343 Forest Ave

Jeff Tarling <jst@portlandmaine.gov>
To: Matthew Grooms <mgrooms@portlandmaine.gov>

Mon, Aug 21, 2017 at 9:55 AM

PARKING PLAN

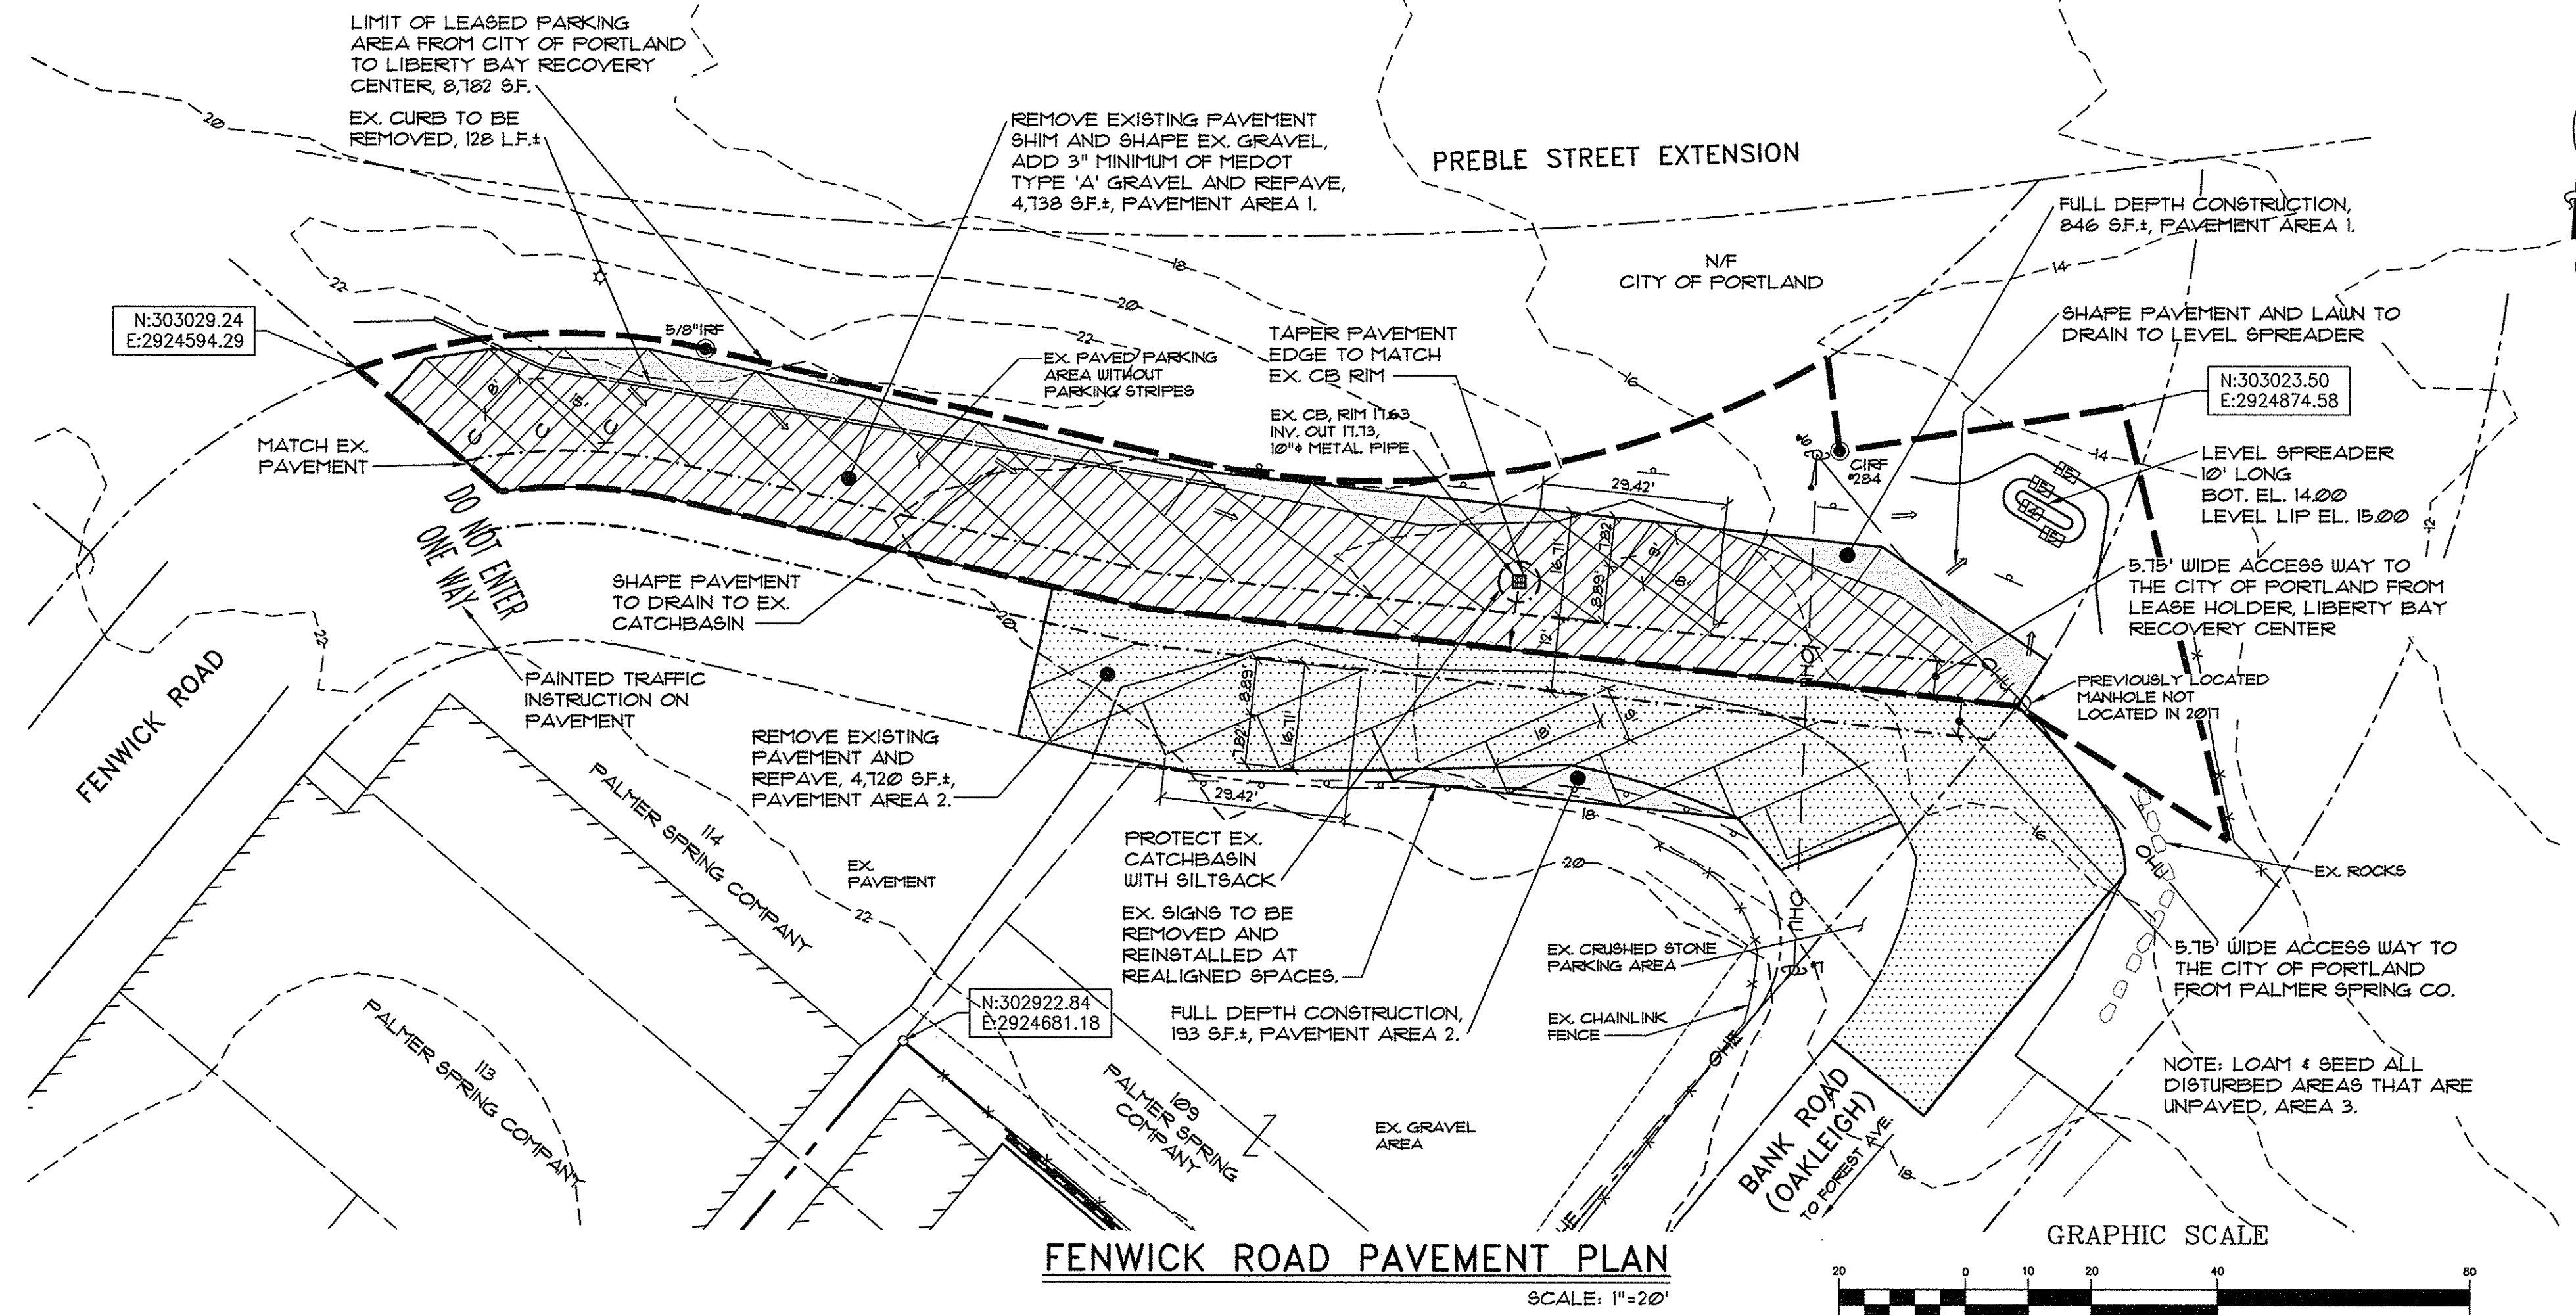
It would be good to better define Bank Street and the adjacent parking area, a small landscape island with a tree or two would be the preferred solution to define the parking lot from the right of way.

If this is problematic due to the loss of parking spaces pavement markings should be maintained and the gravel section of Bank Street could be posted for No Parking (the City PW Traffic group might do this since it is in the right of way)
